re. Planning application P/123/24/HH
109 West Front Road, Pagham

I refer to the above Application, which proposes the installation of an externally mounted ASHP on the south elevation of the building facing the upper beach, which is designated as part of Pagham Harbour SSSI. I agree with the Environmental Health Officer's comments that the proposed heat pump is likely to be un-neighbourly and intrusive to the adjoining property, 107 West Front Road, and believe that the heat pump should be re-sited.

Proposed Elevations

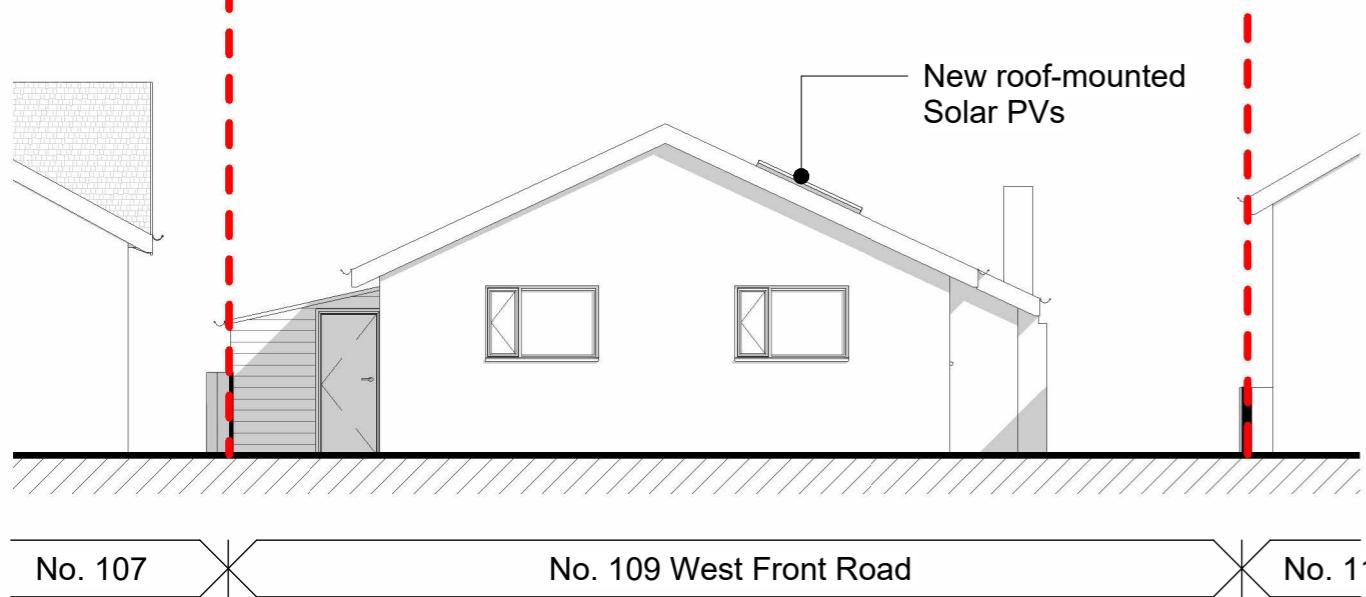
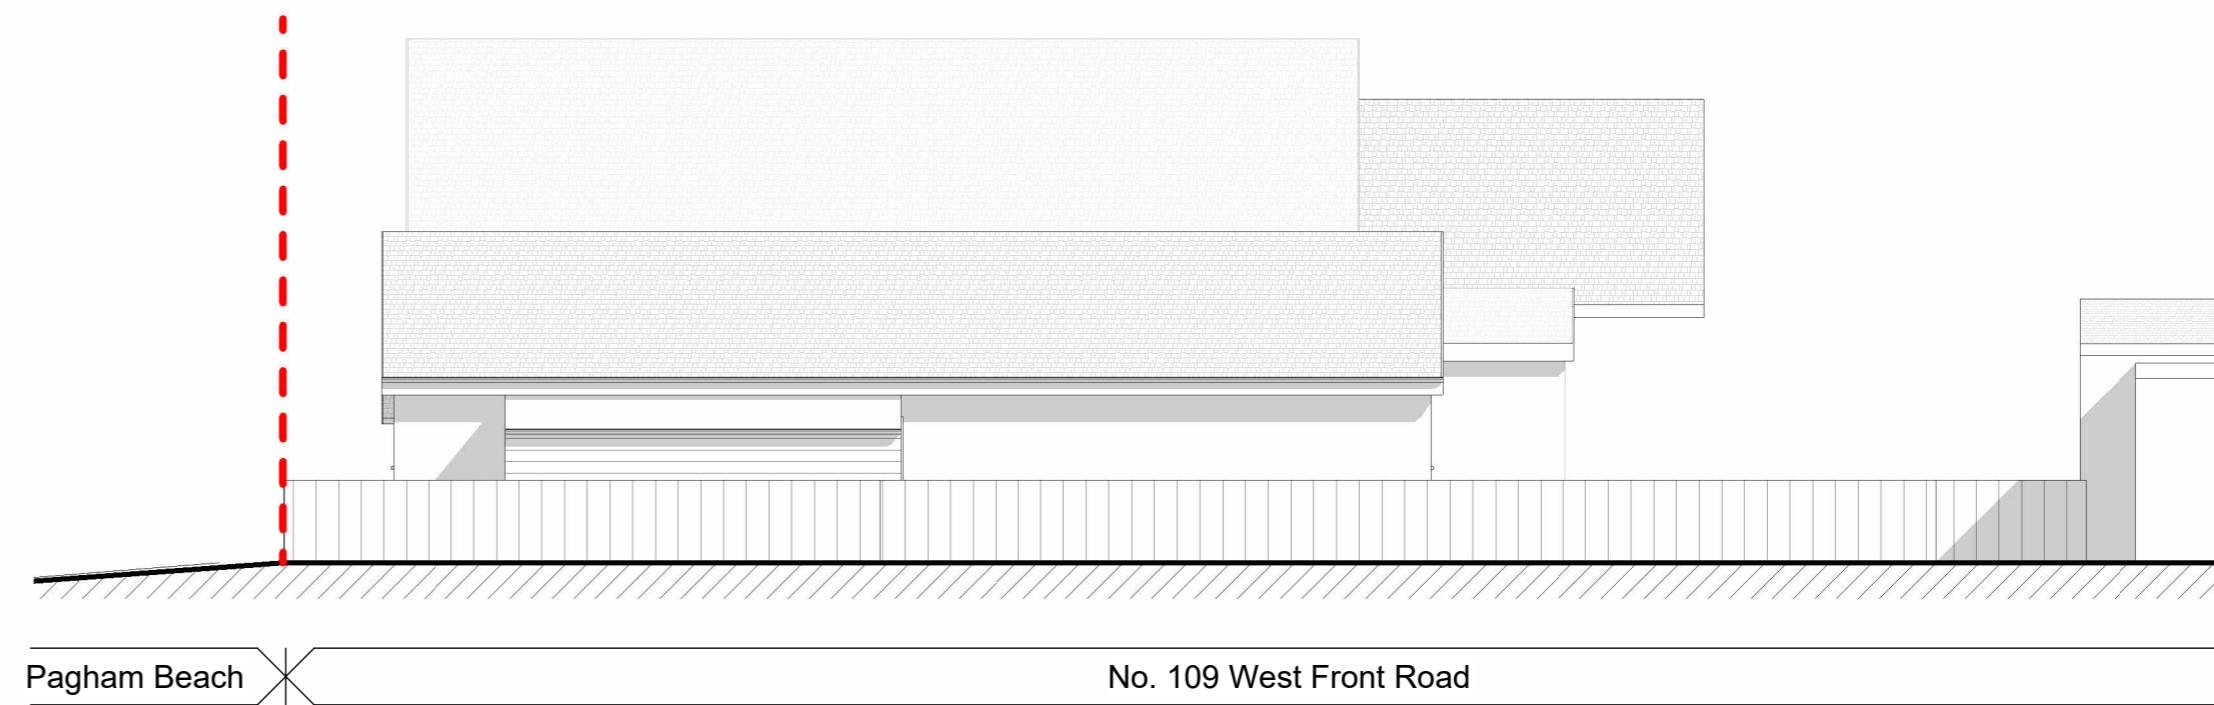
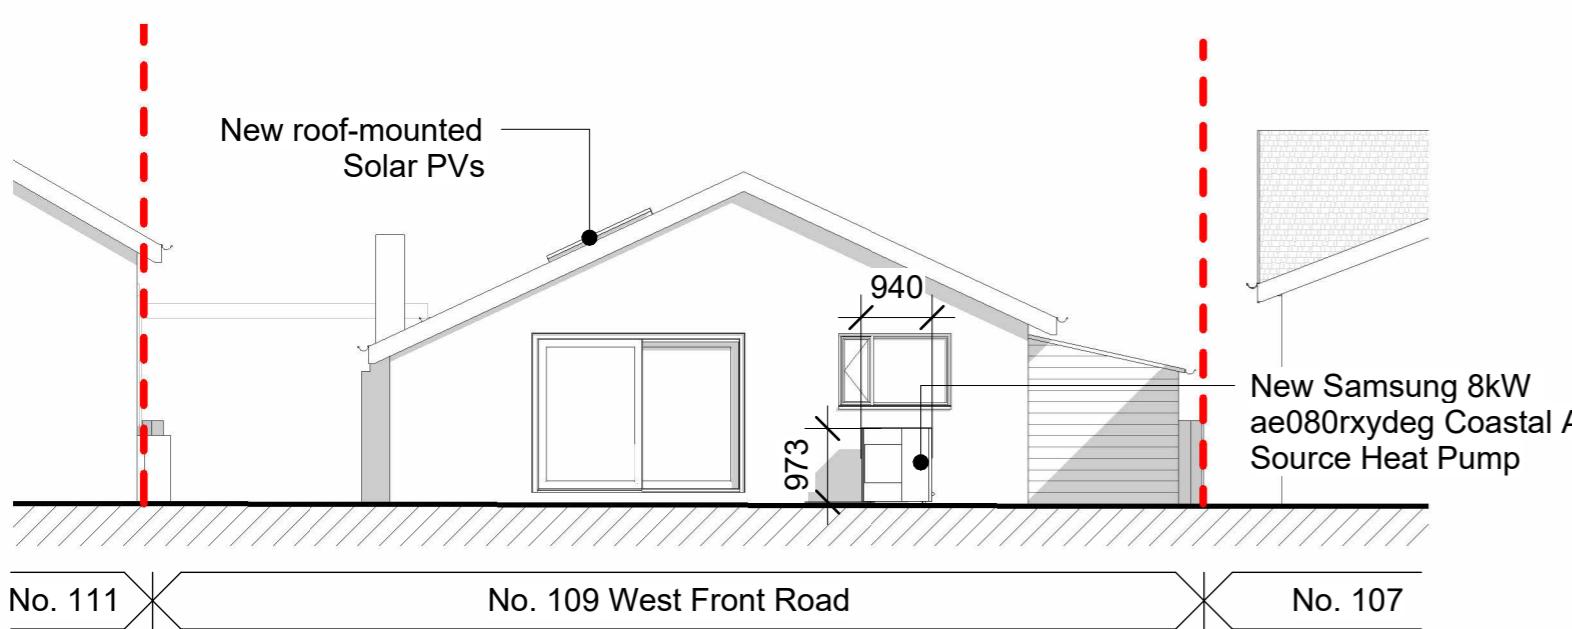
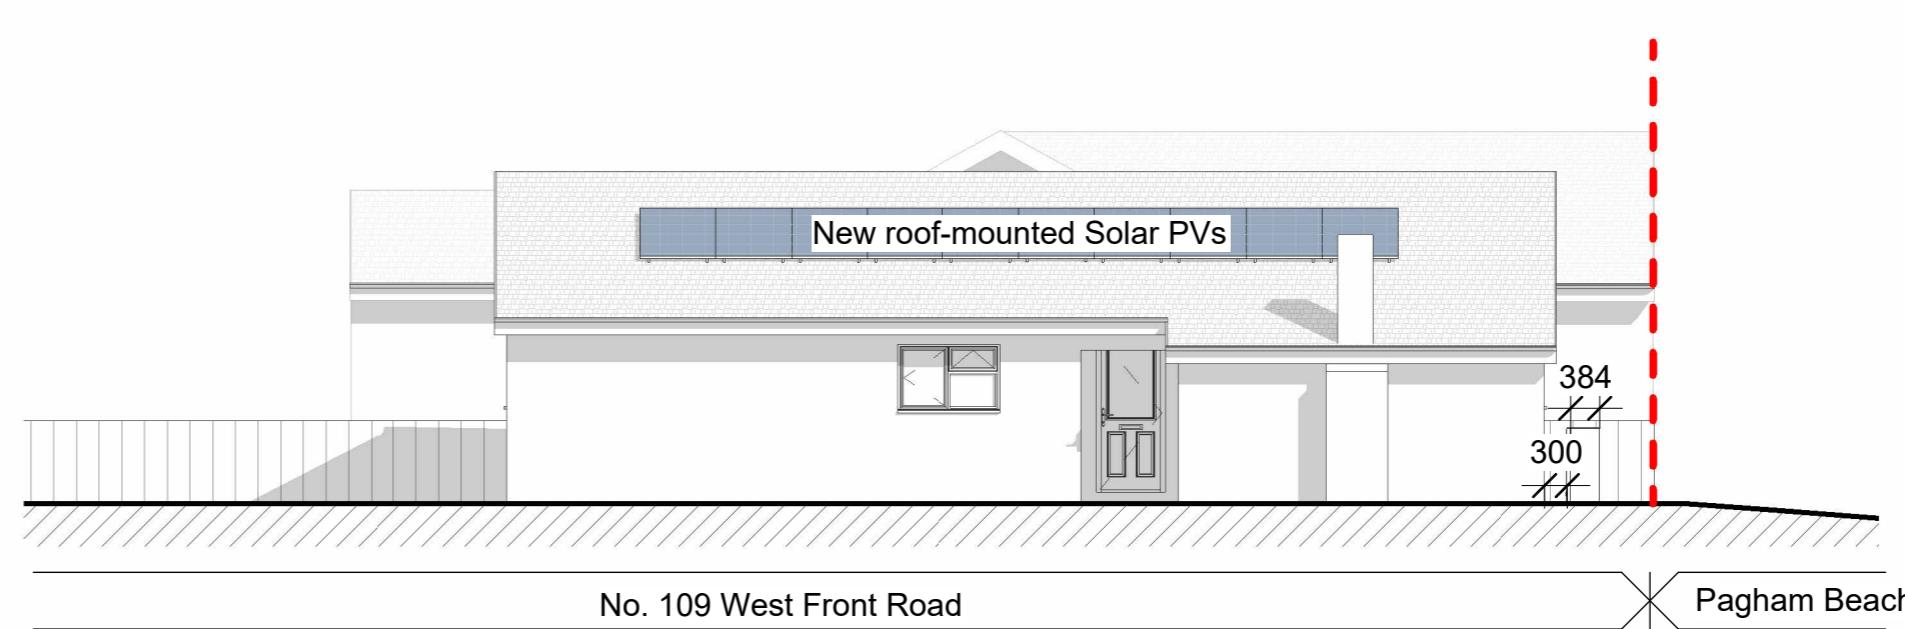
From personal experience I consider fixing the HP to an external elevation of the subject property, would also be intrusive to the residents of 109 and this current proposal should certainly be re-considered.
